DRB CASE ACTION LOG (SITE PLAN B.P.)

DRB Application No.: 05DRB-01482 (SBP)	Project # 1003983
Project Name: DWIGHTS GLASS & GLAZING	
Agent: Mullen Heller Architecture	Phone No.: 268-4144

MEMORANDUM

SUBJECT: Project # 1003983, Lot 1 of Richfield Park (Dwight's Glass), 4501 Alameda NE,
Albuquerque, New Mexico

Site Development Plan for Building Permit  
Scale: 1"=30'-0"

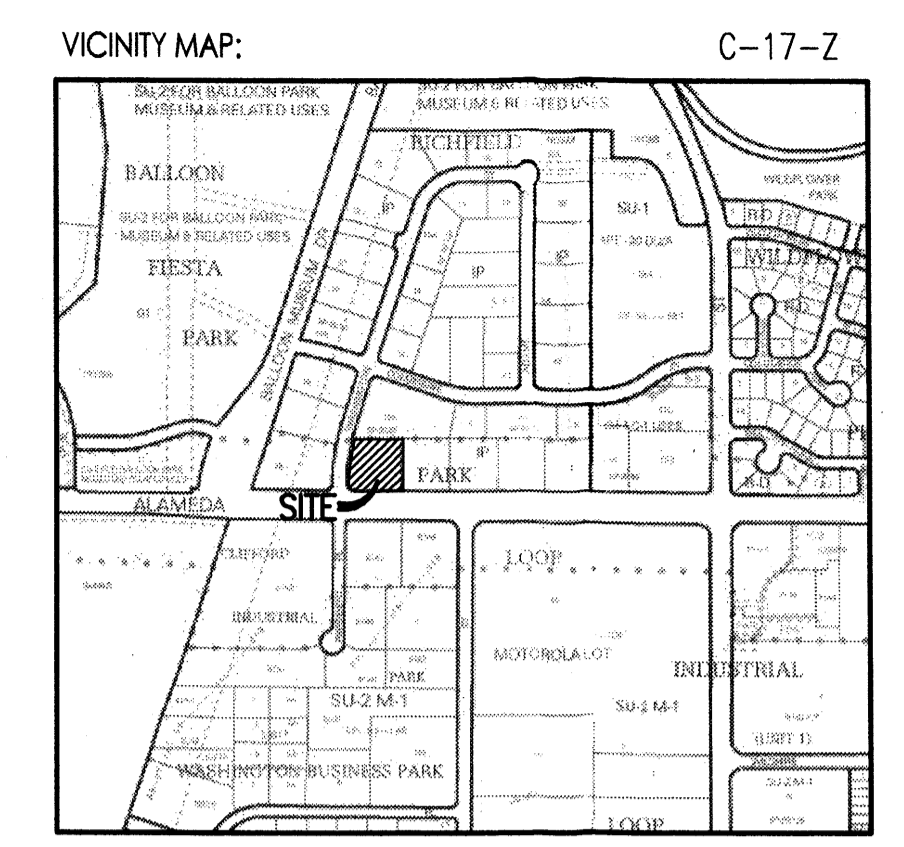
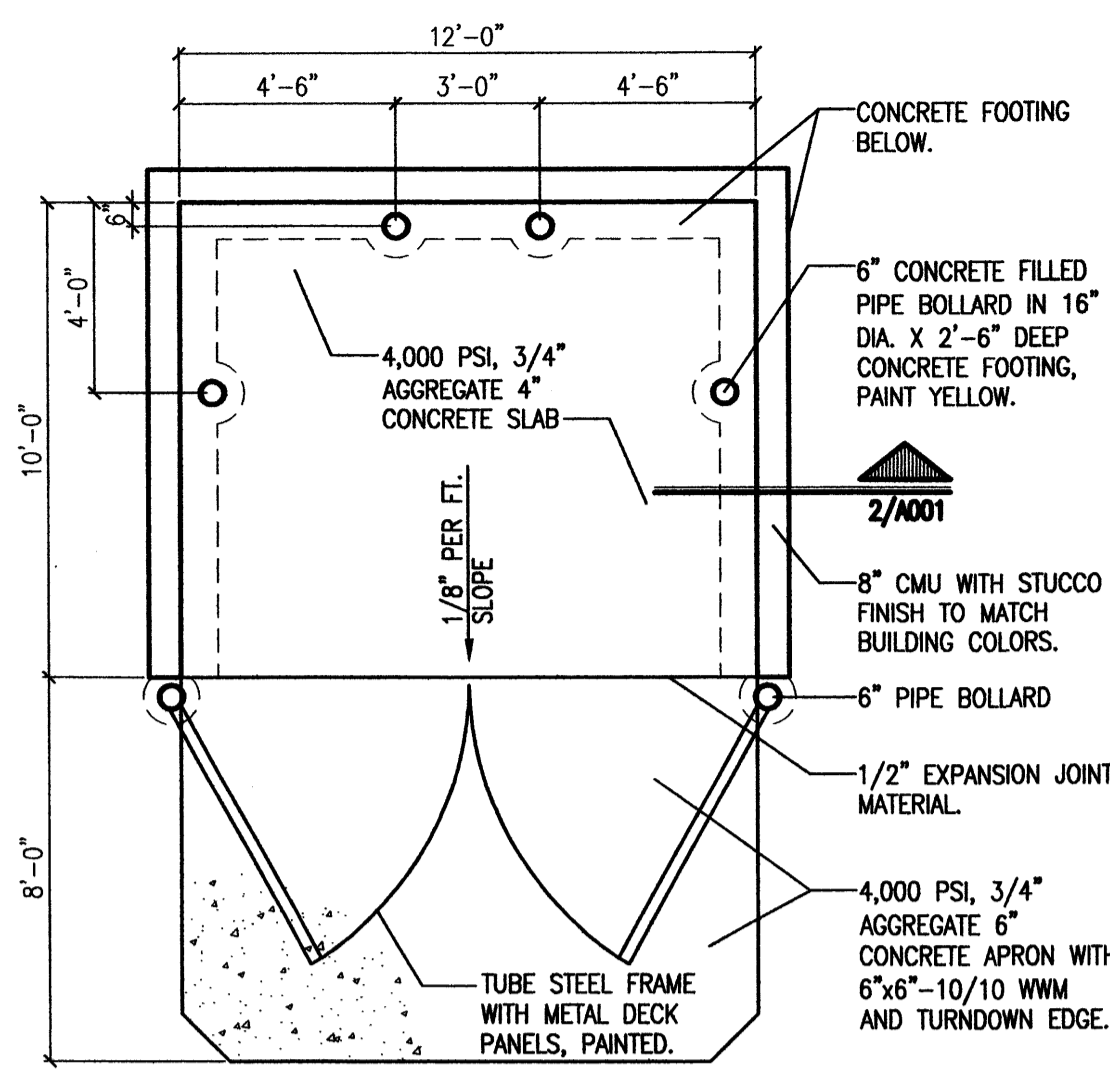
- TRANSPORTATION: - AM DOT APPROVAL FOR TRUNKED ACCESS
- X-LOT ACCESS W/ NORTH PARCEL FOR
- ENTRANCE ON WASHINGTON
- UTILITIES: _____
- CITY ENGINEER / AMAFCA: _____
- PARKS / CIP: _____
- PLANNING (Last to sign): AEHD Signature
- 3 Copies
